**56 Pine St., BP# 2017-00033 plan review comments**

**2 attachments****A101 Floor Plan + Reflected Ceiling Plan.pdf**  
1378K**A201 Exterior Elevations.pdf**  
661K

A201

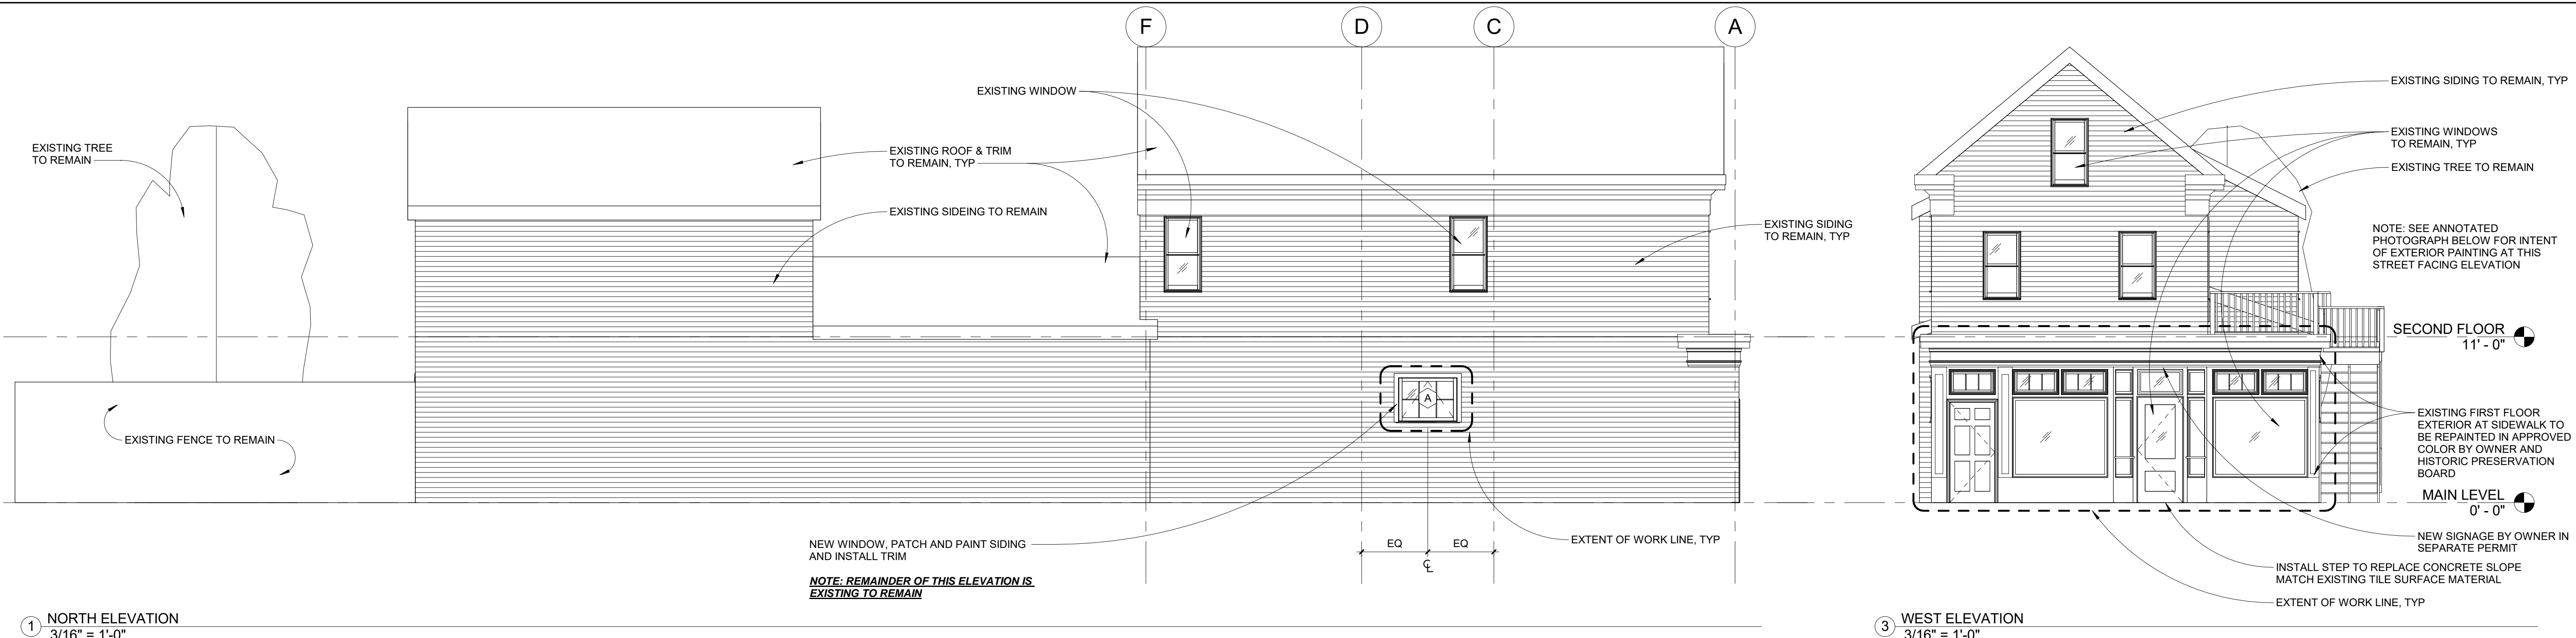
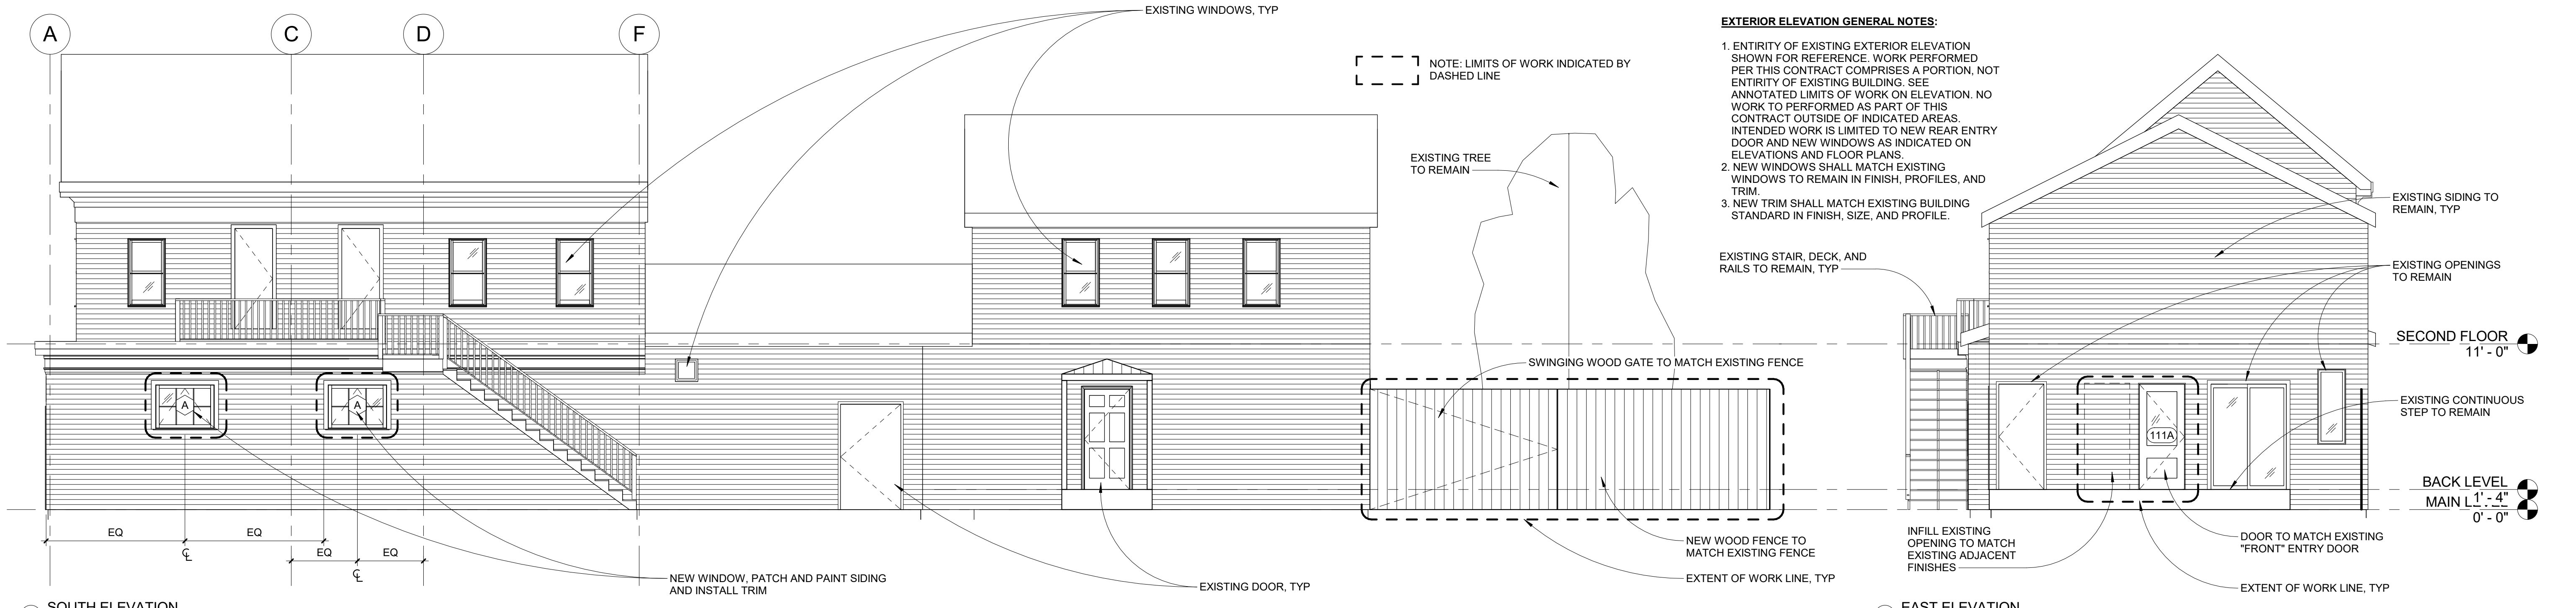
I have completed the review of this project for building code and have the following comments as noted on the attached file(s).

Per your comment, we will not build the window that you indicated does not have the required 5 foot distance from the property line.

Thank you confirming this change, please provide the plan revisions in order for the permit to be approved with the appropriate information. Yes, this was the only item to be addressed on the plans. I understand that the MEP is design/build, as well as fire protection, and I will be putting conditions on the permit for this. Regarding this, the recessed fixtures will need to be fire rated if penetrating the floor/ceiling membrane above.
